219609.01
15 June 2026
R.006.Rev0
DIH:jl

Response to Remediation SSDA Comments Proposed Warehouse Development 49-61 Stephen Road, Banksmeadow

The following provides responses by Douglas Partners Pty Ltd (DP), in consultation with ESR Australia Pty Ltd (ESR), to the additional information sought by the Department of Planning, Housing and Infrastructure (DPHI), DPHI (2026)¹. This is with respect to the State Significant Development Application (SSD-65924461) and the associated proposed warehouse development at 49-61 Stephen Road, Banksmeadow.

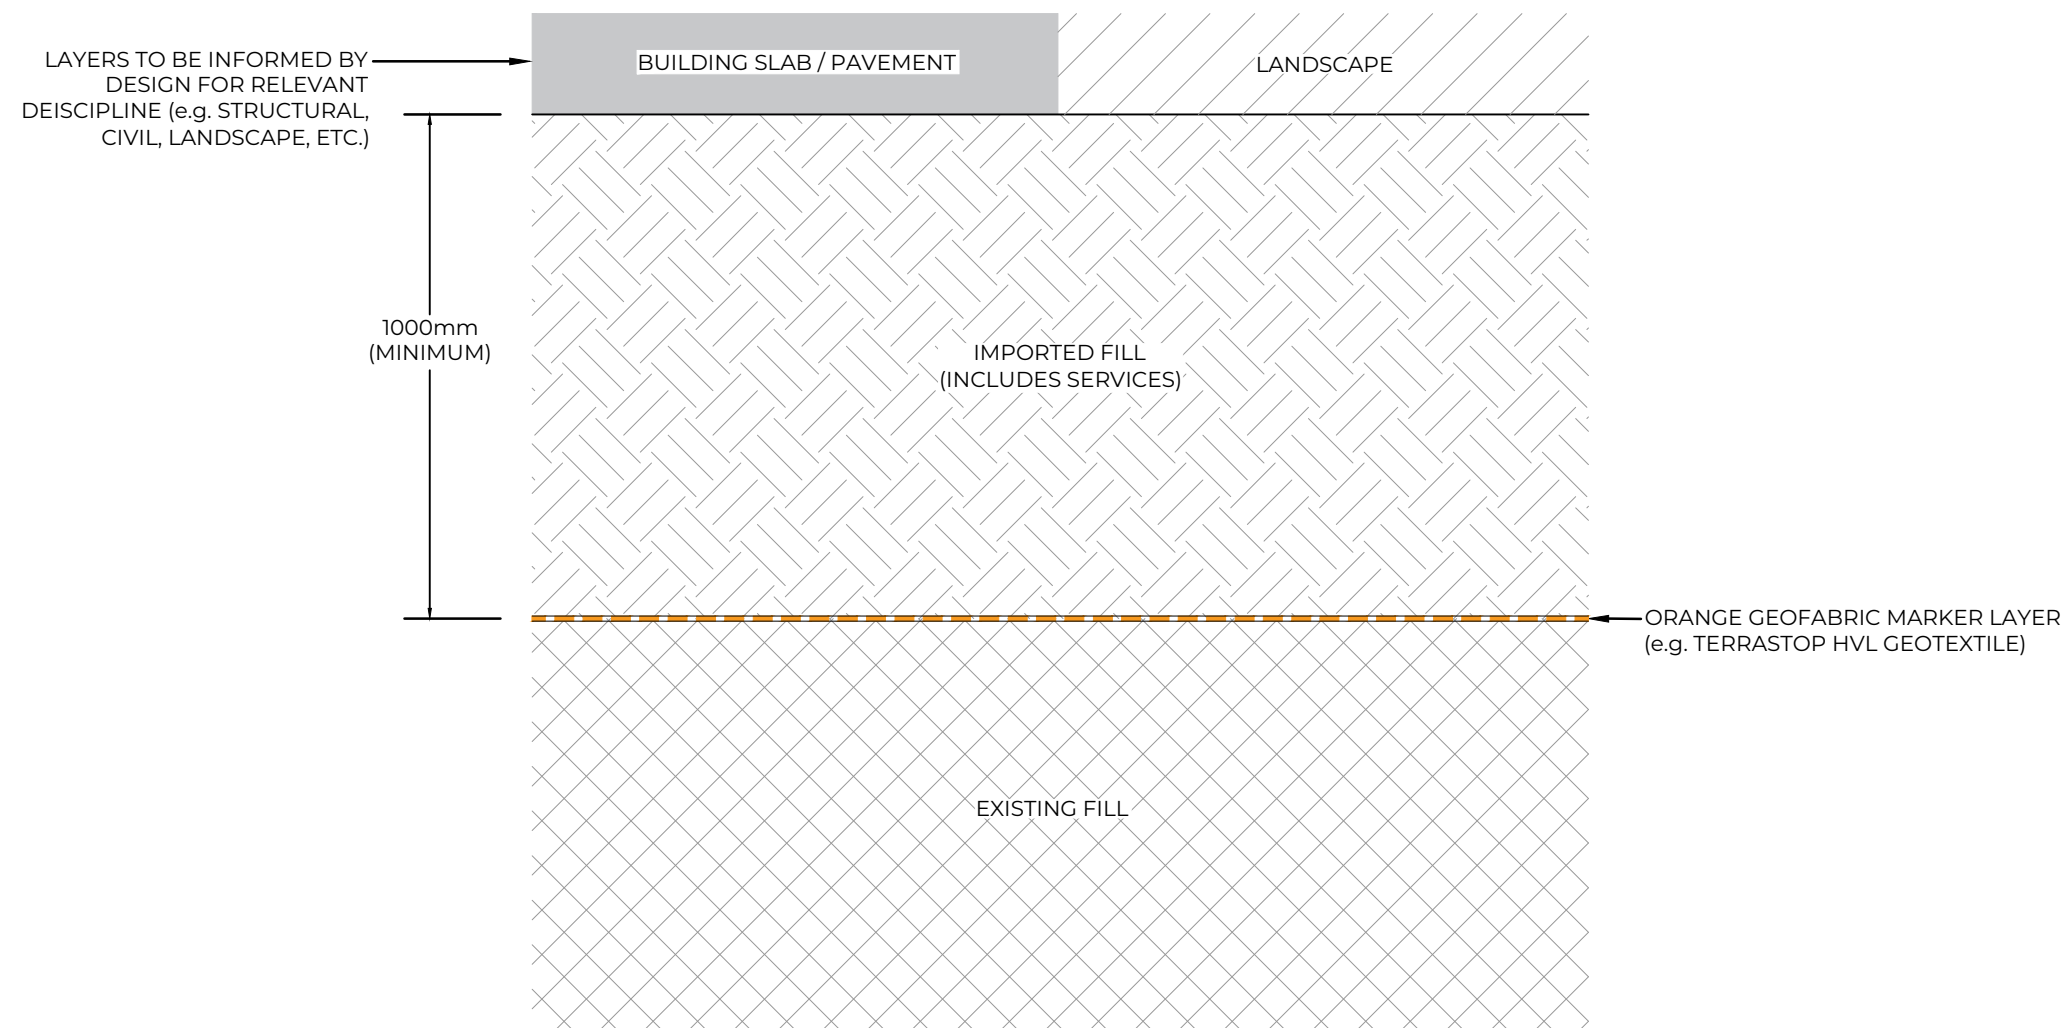
The Remedial Action Plan (RAP) proposes placing soils containing organochlorine pesticide concentrations exceeding the remediation criteria within a containment cell. Additional information is required to clearly define the location and design of the proposed containment cell, its relationship to the overall development, and to provide written interim advice from the Site Auditor confirming acceptance of this approach.

Areas with OCP impacted soils are shown on Drawings 8, 8A and 8B in Appendix A1 of the RAP (also attached).
 - o 1,300 m³ for soils with high lead concentrations above 15,000 mg/kg, namely from the vicinity of boreholes 210 and 333 in Area 6. Whilst preferable and recommended to place this material in the cell, it is not technically required.

- **Section 10.2 of the RAP - Placement of OCP impacted soils with concentrations above the RAC in a contaminated cell.** This refers to the soils located around JBS&G sample location BH67 (indicated by yellow hatching on Drawings 8 and 8a from the RAP). Placing these soils in a containment cell will remove exposure pathways associated with direct exposure and the potential to impact groundwater quality.
